Please ask for: Ms Iqraa Malik
Email: iqraa.malik@terraquest.co.uk
Telephone: 0121 234 1390
Our Ref: BN/69/22/HH
Your Ref:
Date: 26th May 2022

Application for Planning Permission for Works or Extension to a Dwelling

Development: Erection of two storey side and single storey rear extension including installation of rooflights following demolition of existing side/rear extension.
Location: 15 Critchmere Road Eastergate PO20 3XA

PROJECT	15 Critchmere Road Eastergate	SUITABILITY	Planning	DATE	05.2022
DRAWING TITLE	Existing Building	SCALE	1:100@A3	DRAWING NUMBER	PL-05
				REVISION	A

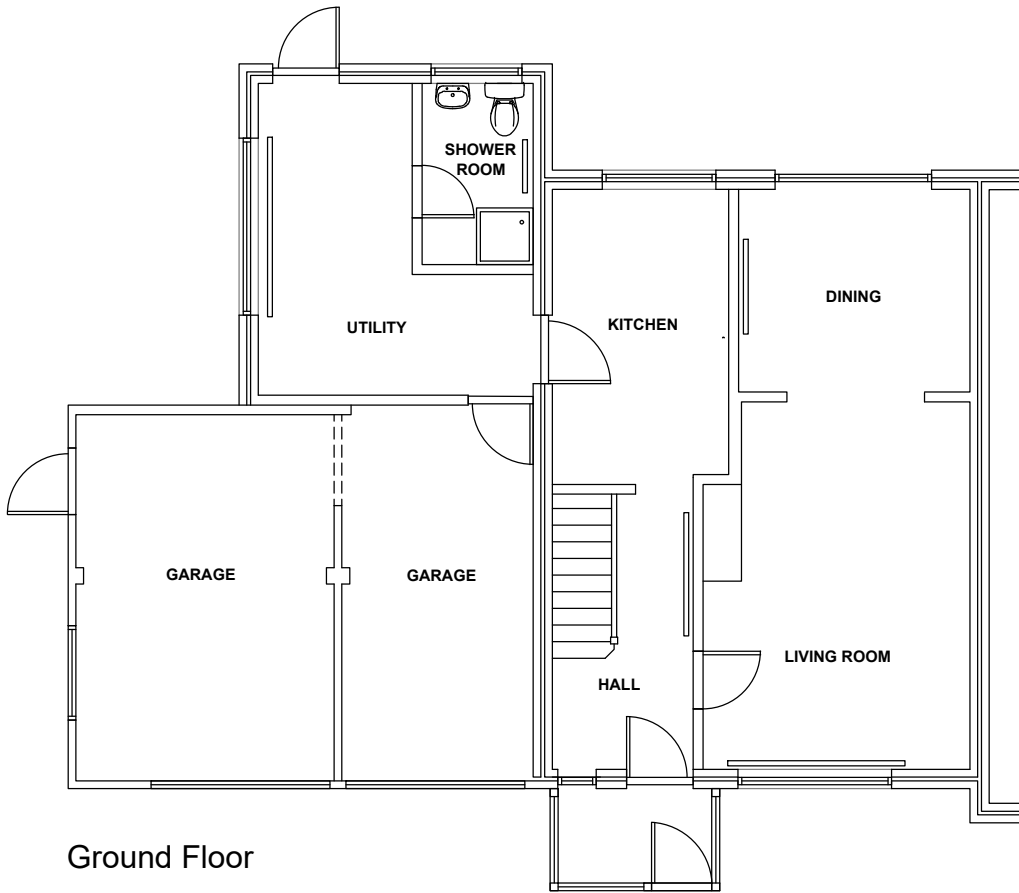
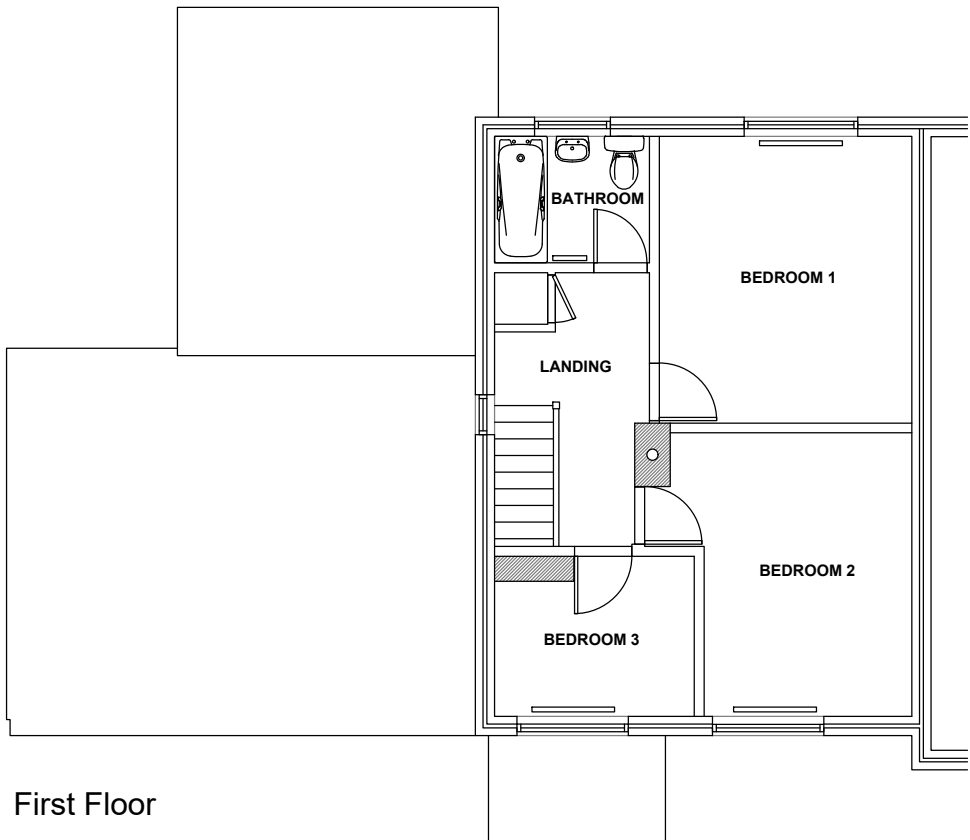
The windows on the existing ground floor plan is inconsistent with the existing south elevation. Please review and amend.
